From: Andrew Wood
Sent: 21 March 2019 13:47
To: Planning.Responses
Cc: [REDACTED]
Subject: FW: Planning Consultation on FG/4/19/DOC
Attachments: 17036-W121 RevA - Landscape Plan.pdf; 17036_HNW_PlantingSchedule RevP1.pdf; Yeomans Honda DSP3 Plan.pdf

Amended landscaping scheme and vehicular delivery and servicing plan.

Registered: 10-JAN-19
Site Address: Garage Premises Littlehampton Road Ferring BN12 6PB
Description of Works: Approval of details reserved by condition imposed under ref FG/39/18/PL relating to Condition No 7 hard & soft landscaping and Condition No 11 control of car transporters & deliveries.

Drawing Title
**Proposed Hard & Soft Landscaping
Plan**

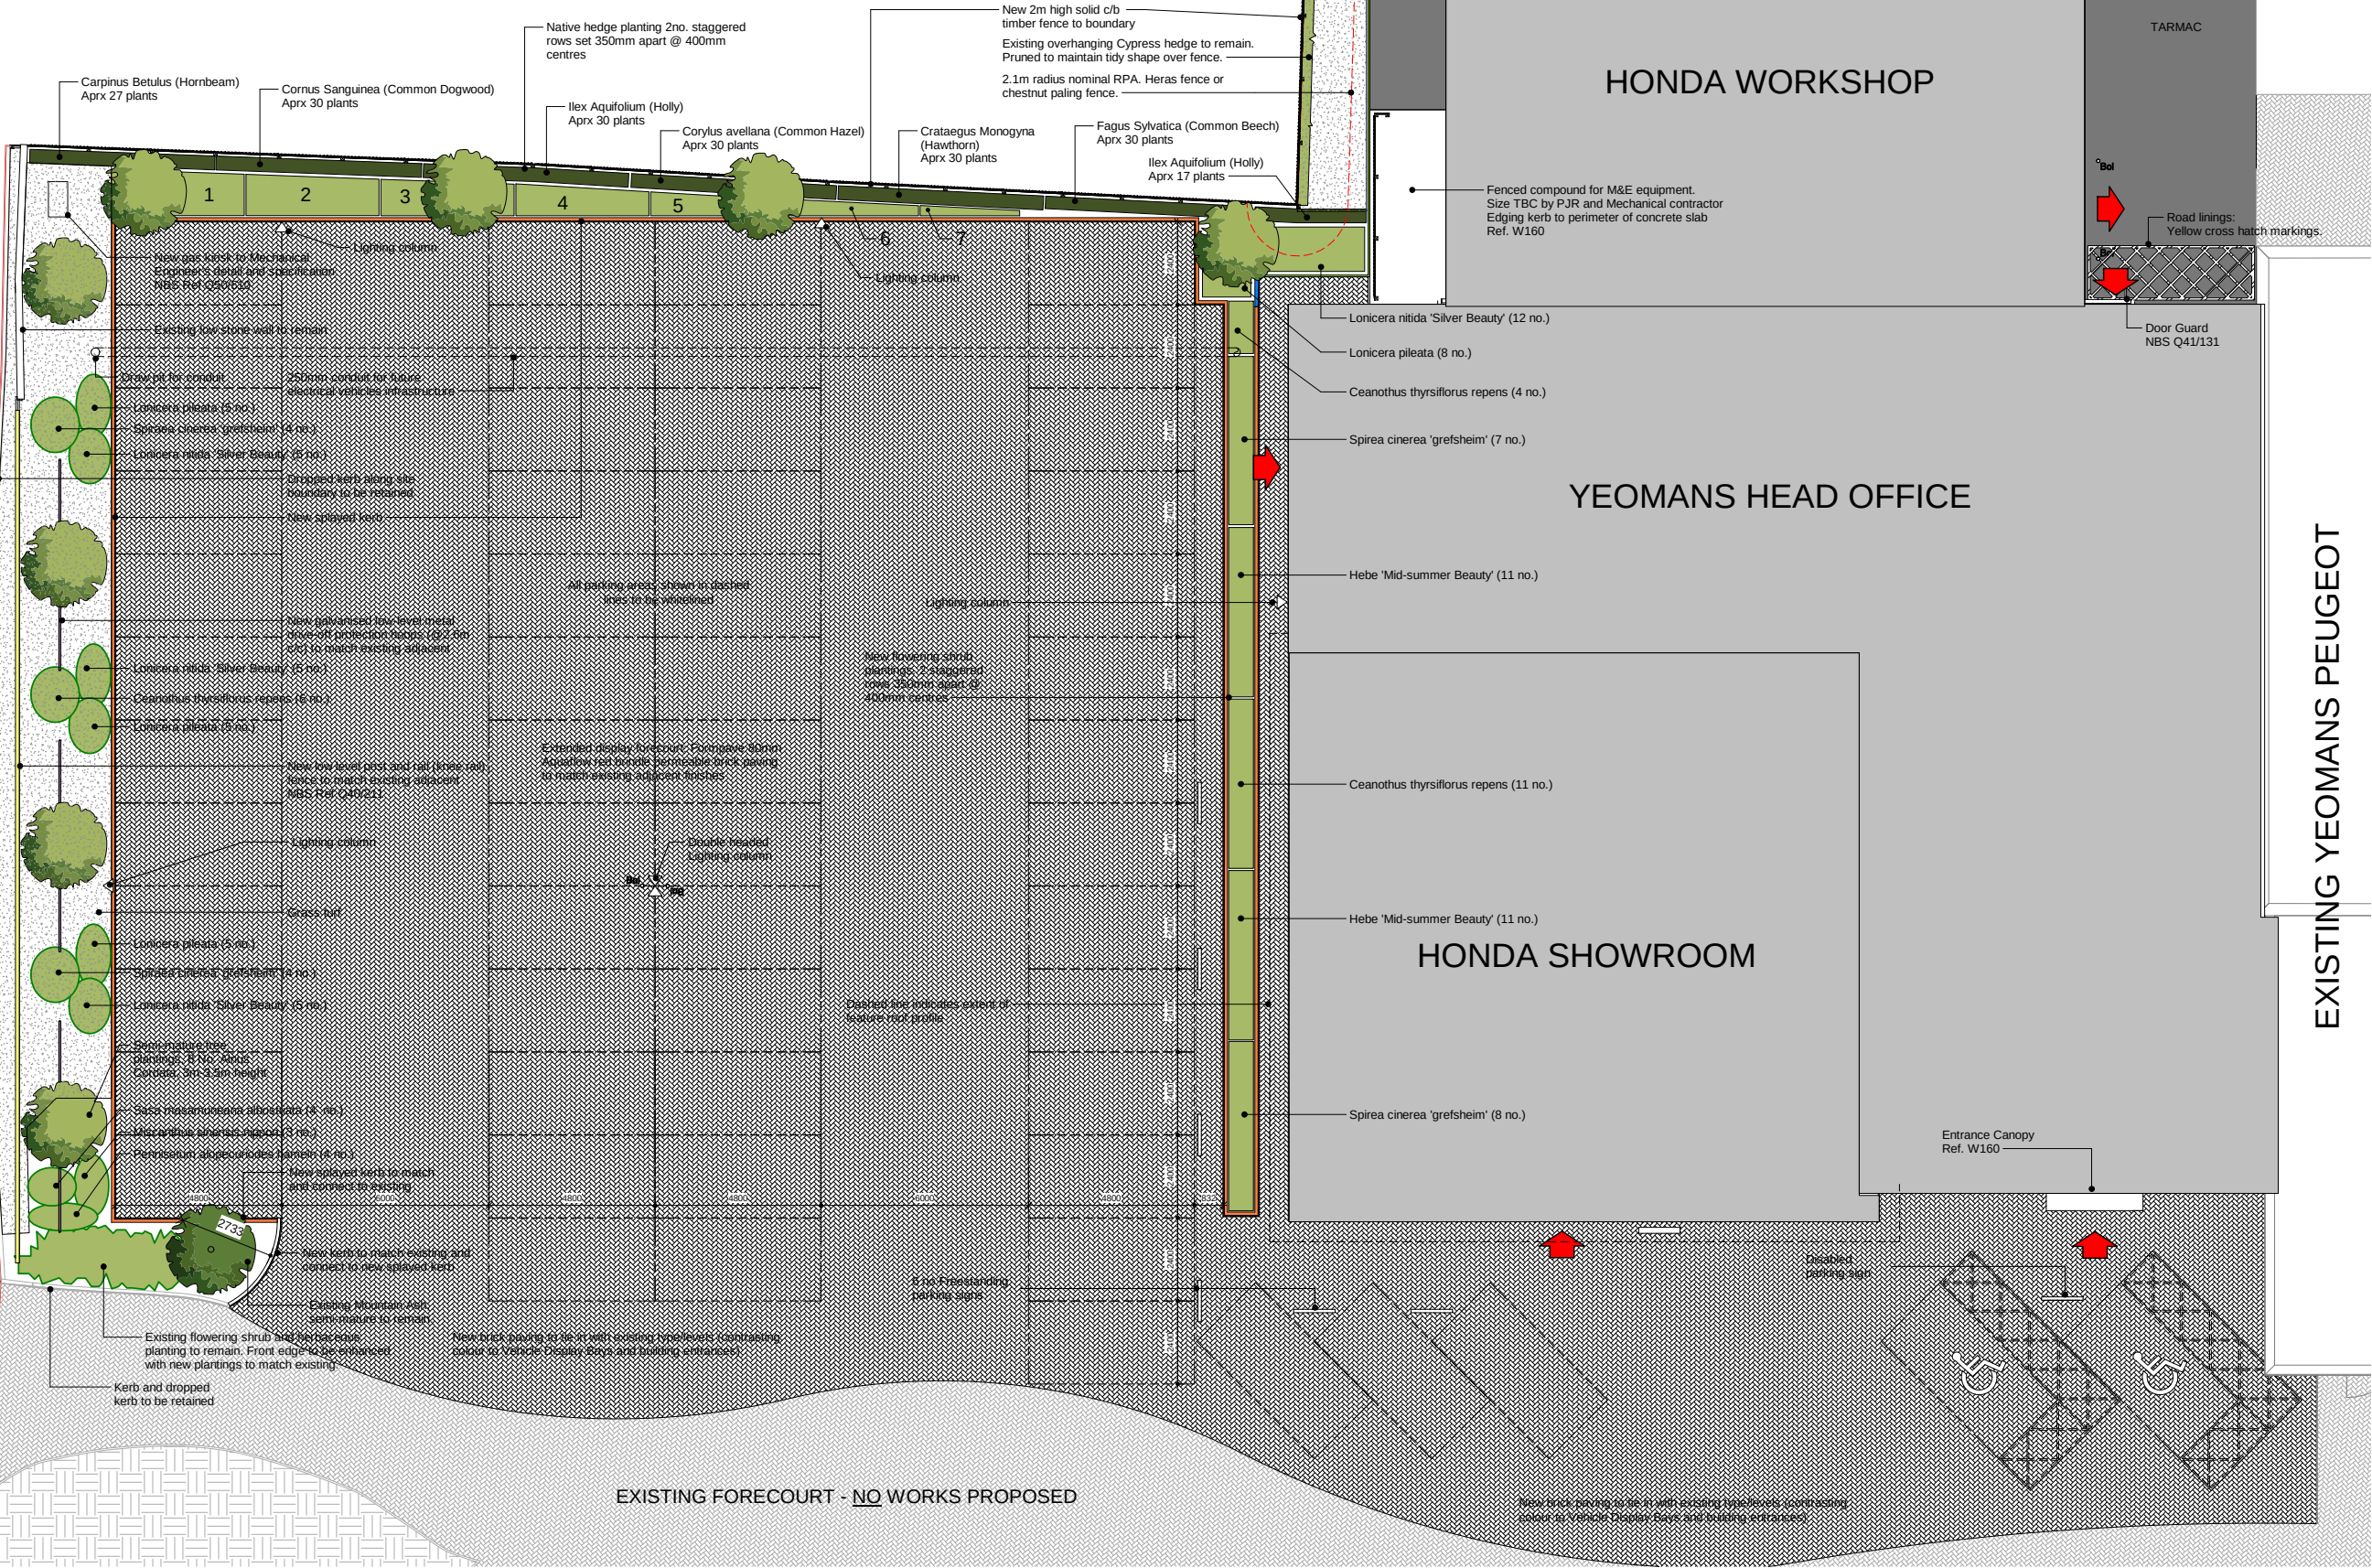
I would query however that the new tree planting to the Western /Hangleton Lane and Northern Boundary are detailed as Semi-Mature stock to match existing, however these are shown on plan and schedule as 10-12cm girth 3-3.5m size tree which are not Semi Mature trees but Select Standards.

Please amend plan/schedule so as to avoid doubt to show Semi Mature stock at 18-20cm+ 4.0-4.5m tall.

Further to our telephone conversation today I can forward the amended planting plan and schedule to reflect the landscape officers comments. You'll therefore find attached revised Planting Plan 17036-W121 rev A & Planting Schedule rev P1.
